Inspector's Report ABP-310347-21.

Whether the construction of 2 no. extensions to the rear of a house is or is not development or is or is not exempted development.

3, Gilford Avenue, Sandymount, Dublin 4.

0135/21.

Proposed Ground Floor Plan

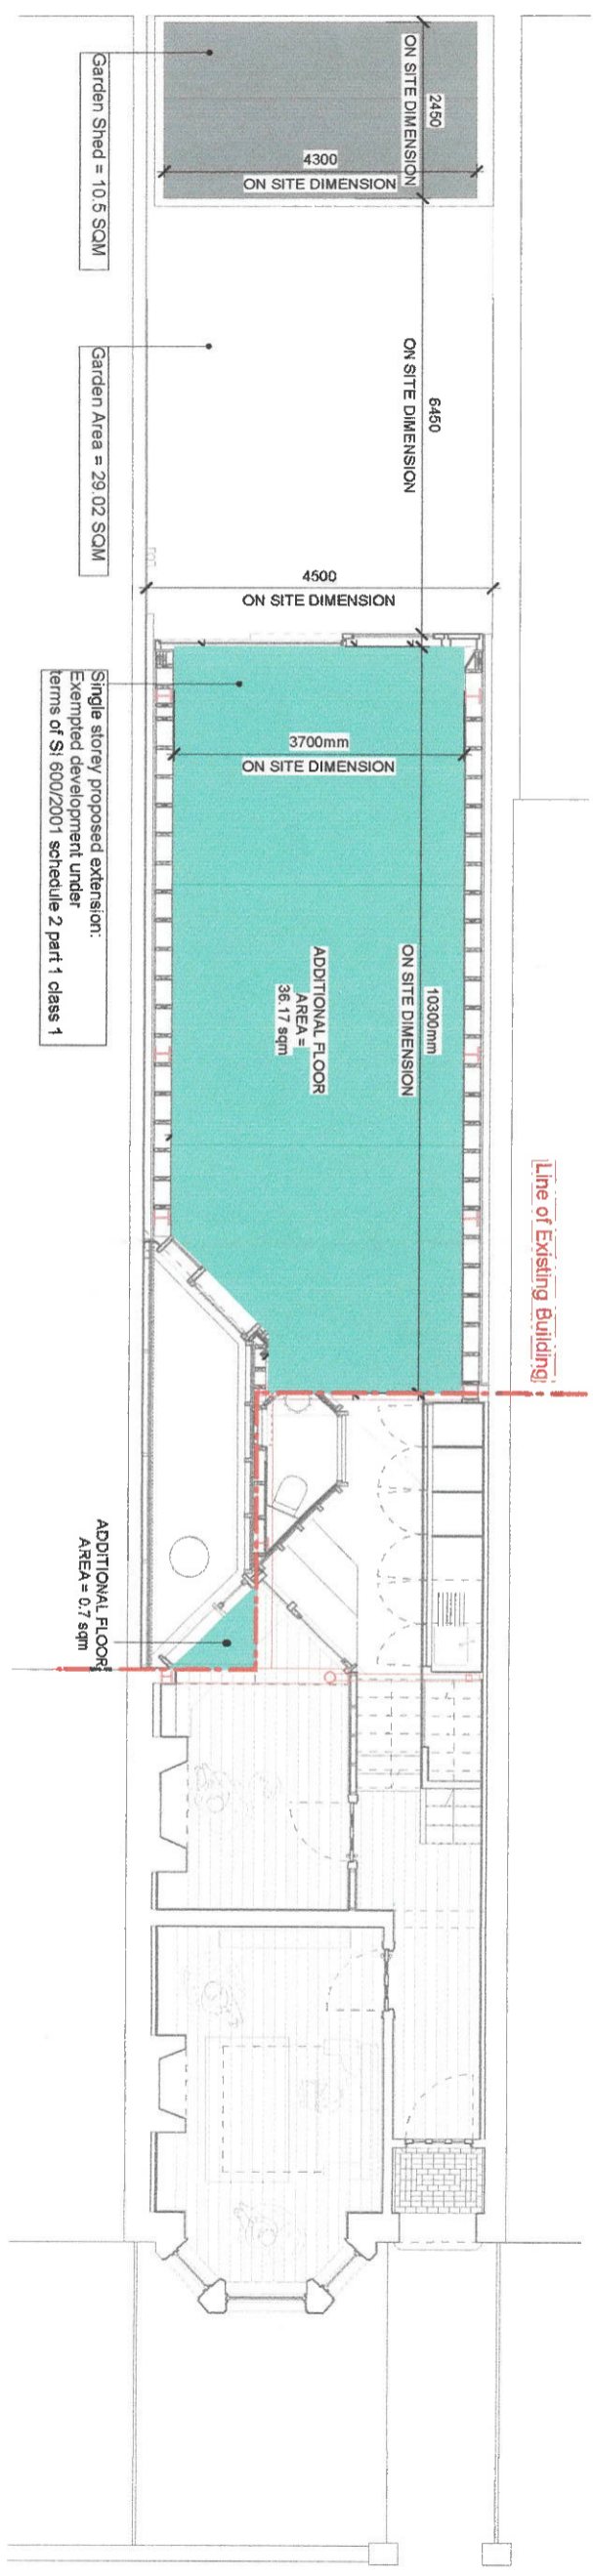
- 8.3.3. I also note that the owners' agent has submitted scaled drawings of the extension which indicate that the floor area of the extension constructed extends to 36.87m², including the small area immediately adjacent to the original rear wall of the house. The referrer submitted drawings which suggest that the floor area extends to 44.5m² which exceeds the 40m² limit for exempted development.

- Part 1(a) - the floor area of the extension as constructed appears to accord with the conditions and limitations.
 - Part 2(a) - I note that there does not appear to be any other extensions to the house which would impact the 40m² limit. I will address the garden shed further below.

PARTY WALL ELEVATION MARCH 2021

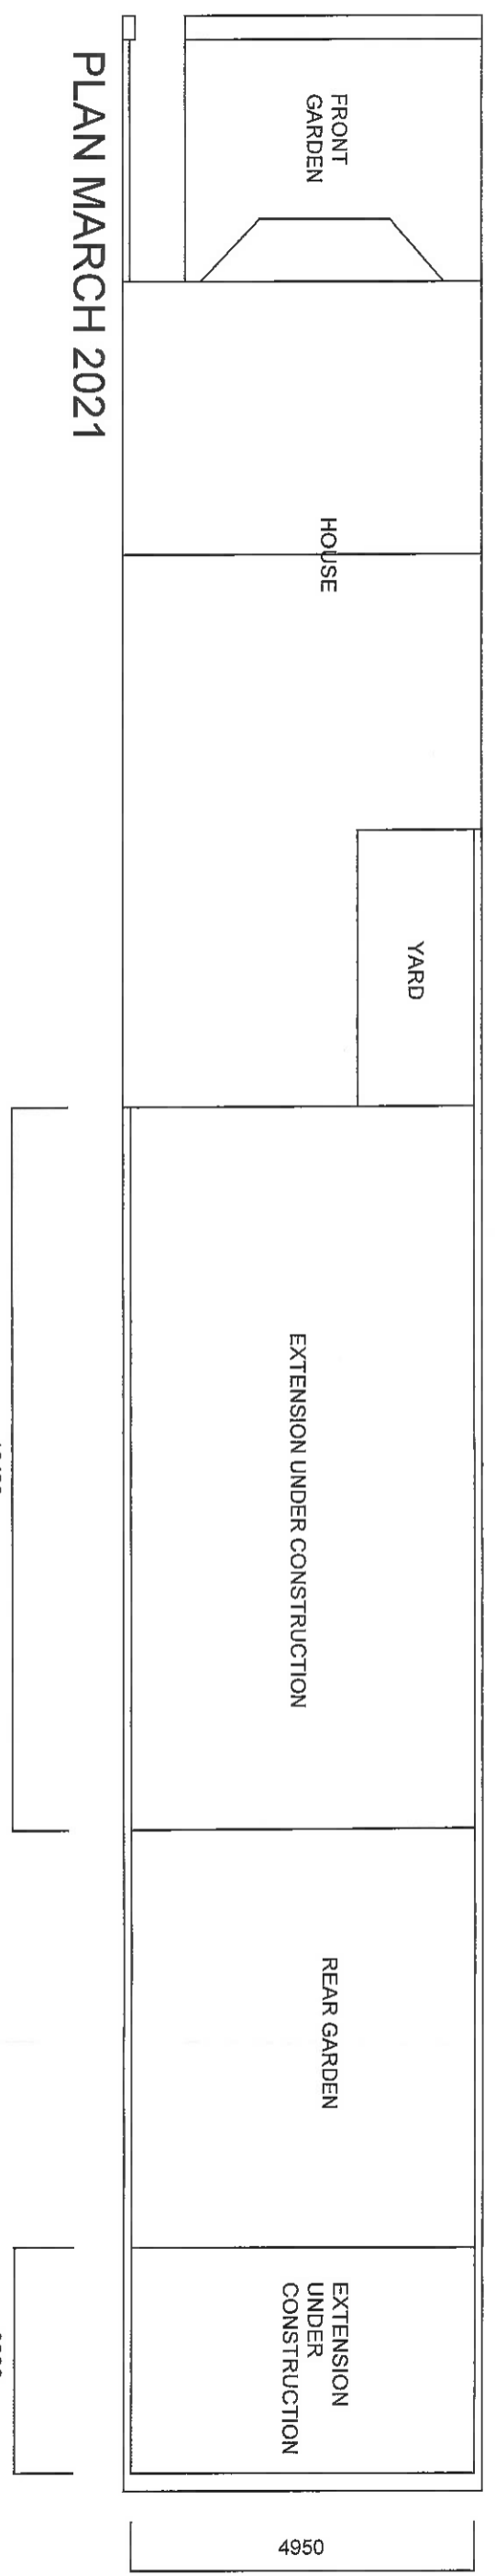
The Board will note that the referrer has indicated that as the rear wall of the main house is 4.331m in height, with a third rising to 5.8m, the main rear wall of the house is 4.331m. The gable wall of the extension rises to an overall height of 5.79m and therefore, does not comply with the conditions and limitations as set out in the exempted development regulations.

I note the conclusion of An Bord Pleanála in relation to PL06.RL2354, where it was determined that ‘it was not correct of the Planning Authority to seek to add to the workings of the Regulations and to qualify the term ‘rear wall’ with the description ‘main rear wall’’. In this case, the Board agreed with the Inspector that the single storey section was not a separate construction, but physically connected to the main body of the house. In this regard, given the ‘gabled’ nature of the southern wall of the extension as constructed in the subject case, together with the information provided by the third party (and lack of scaled elevational drawings from the owner / occupier), this wall exceeds the height of the rear wall of the existing house.

8.3.5. Having regard to the question before the Board and taking into consideration the precedent of similar referral questions in the past, I must conclude that the extension as constructed is development and is not exempted development as it does not comply with condition and limitation (4)(a) as set out in column 2 of Class 1 of Part 1 of Schedule 2. The extension is therefore considered to be development and not exempted development.
